Date: October 17, 2025

Re: 25-FRM-227
Garage Pony Walls
Lot 142 Tobacco Road
216 Crop Rd.
Angier, NC 27501
Permit No.: SFD2508-0046

At your request, a site visit was made to the above referenced single family residence under construction to address the pony wall heights above the garage door openings.

2.01F
First Floor Framing Plan
Elevation "A"

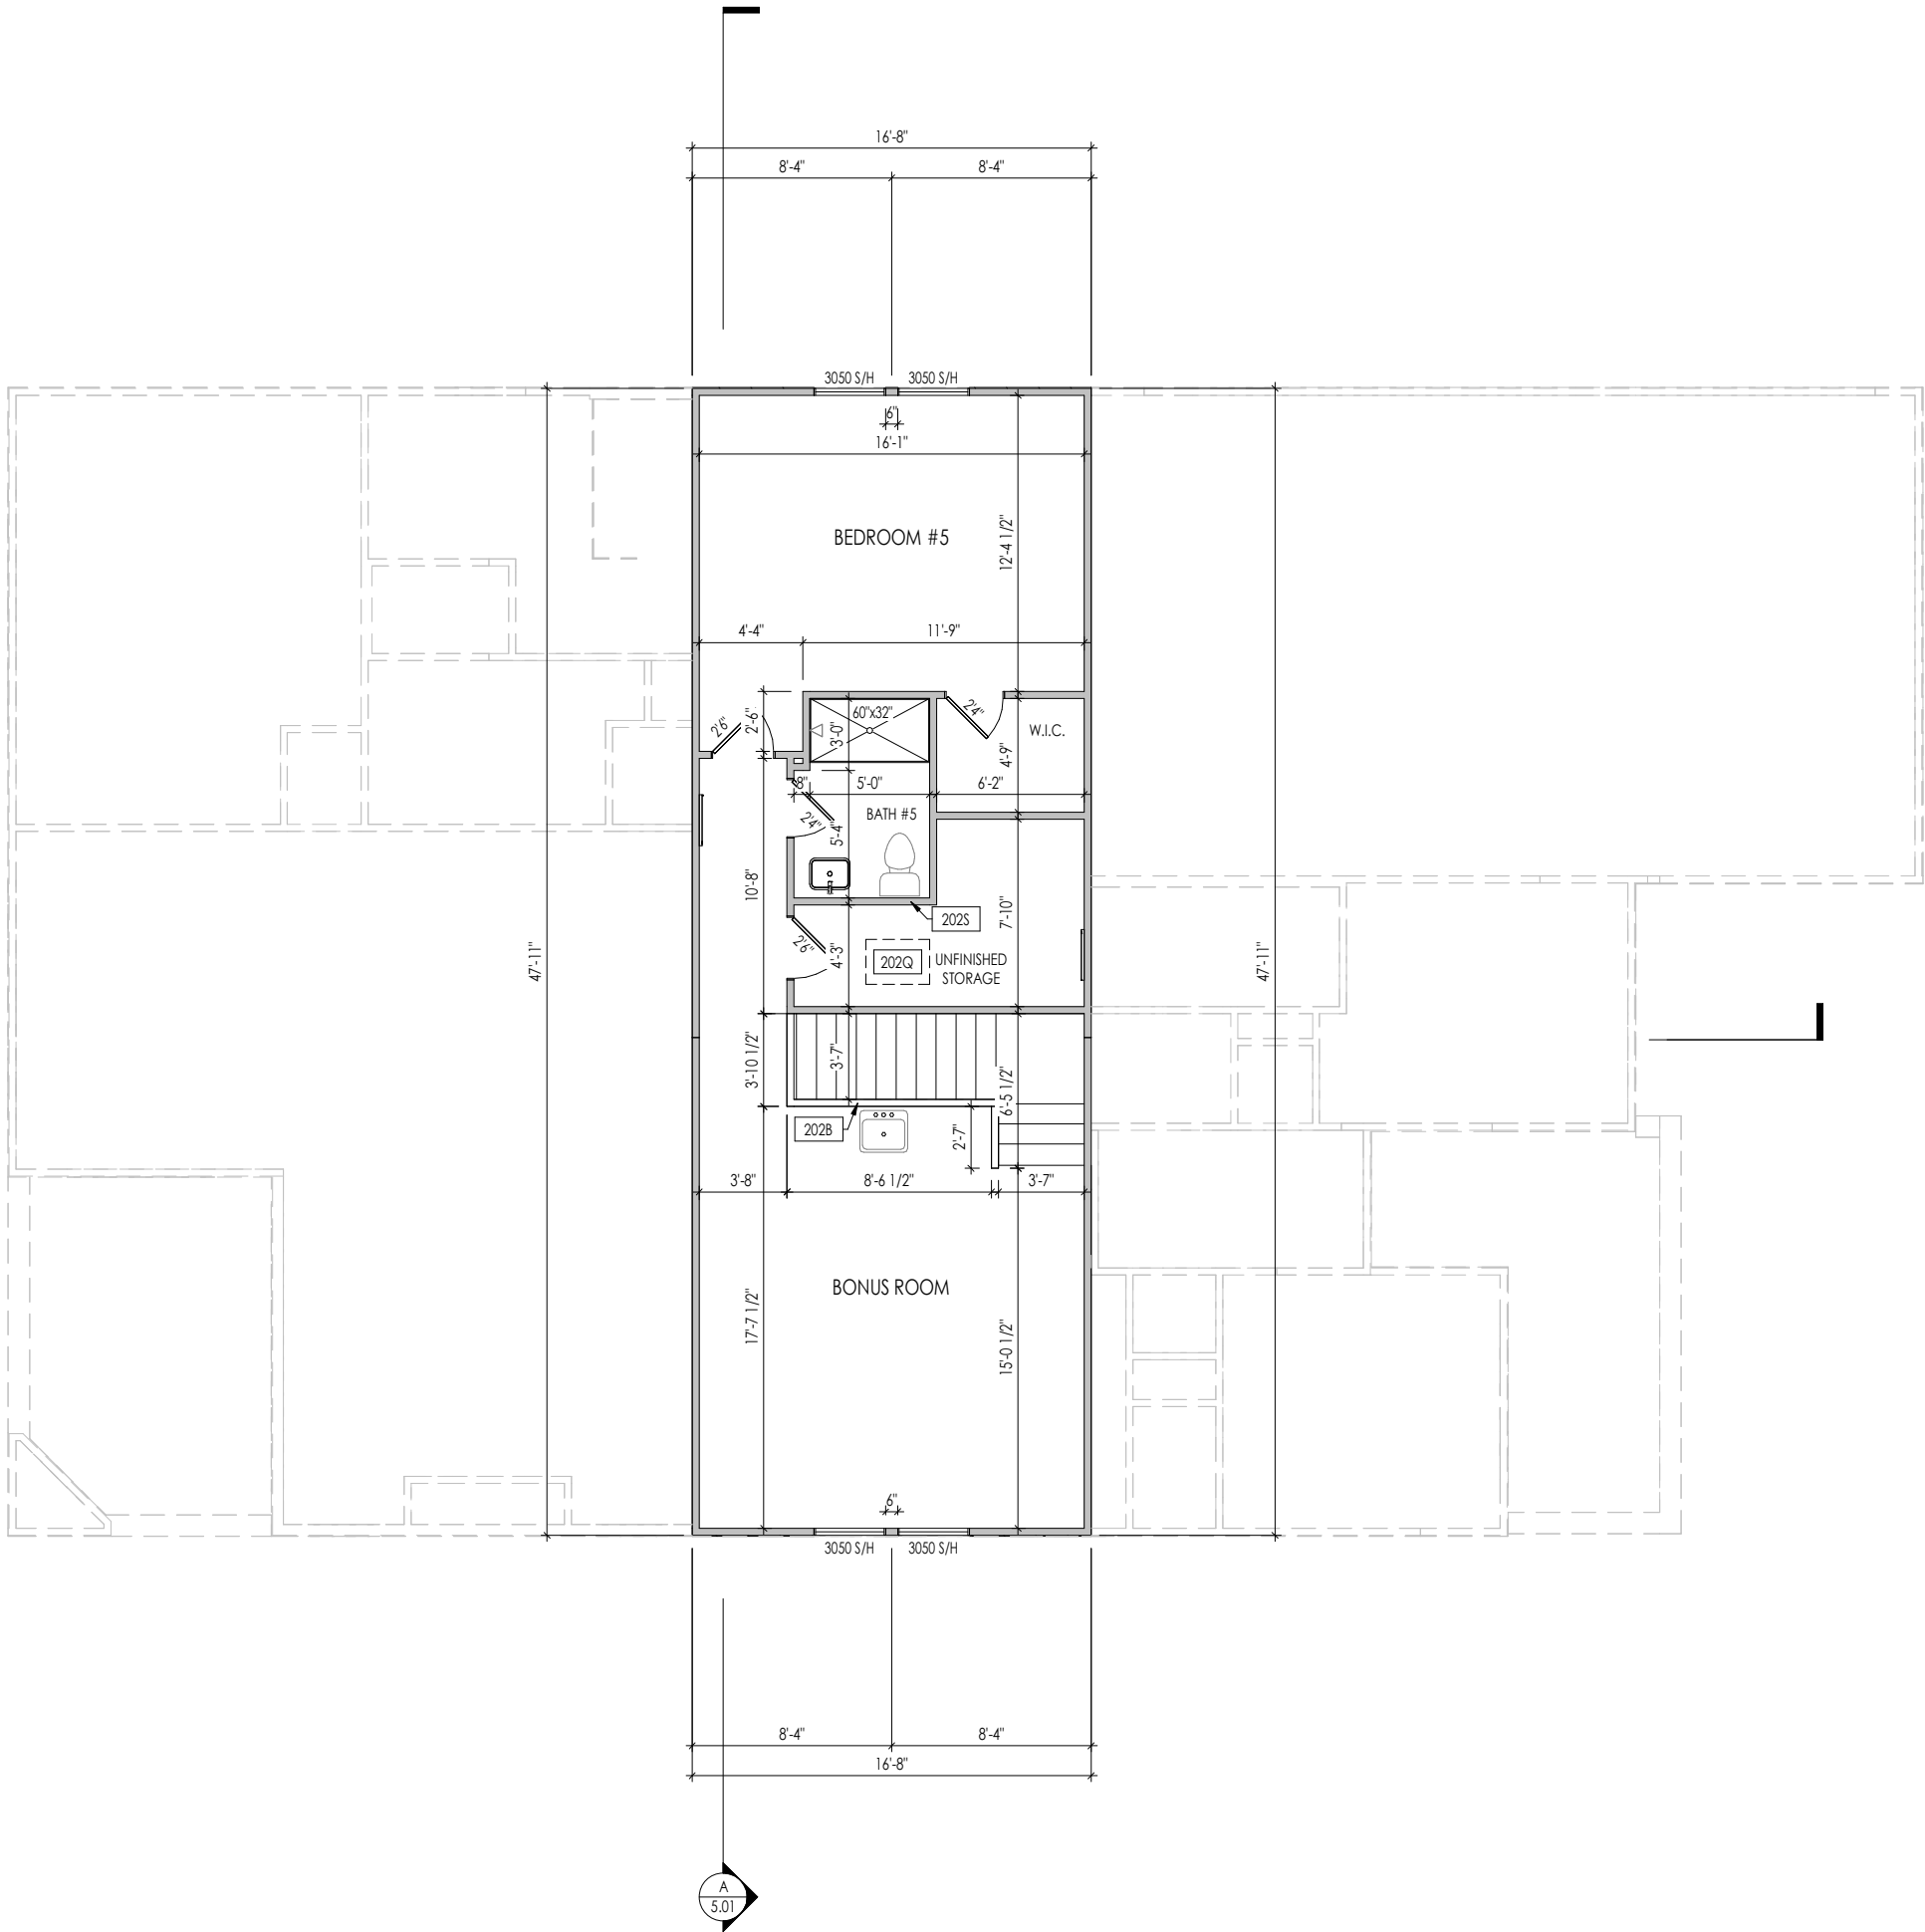
The 2x4 @ 16" o.c. pony walls above the garage door headers were measured to be up to 4'-3" in height, exceeding the maximum allowable height of 3'-0" per plan. The roof trusses to the rear of the 2-ply girder truss span front to rear, parallel to the left exterior wall. The roof trusses to the front of the 2-ply girder truss span left to right, bearing on the pony walls above the one-car garage door header.

Secure every other pony wall stud (32" o.c. maximum spacing) to the garage door headers below with a Simpson Strong-Tie CS16 strap with minimum 11" end lengths. Where the roof trusses span parallel to the pony wall, furr out the gable roof truss bearing on the pony wall above the garage door header and install a Simpson CS16 strap at the top of every other pony wall stud to extend onto the truss with minimum 11" end lengths. Cut out sections of the nailer on top of the pony wall as needed to allow for flush installation of the straps. Where the roof trusses bear on the pony wall, tie each truss to the pony wall above the garage door header with a Simpson Strong-Tie H2.5A hurricane tie.
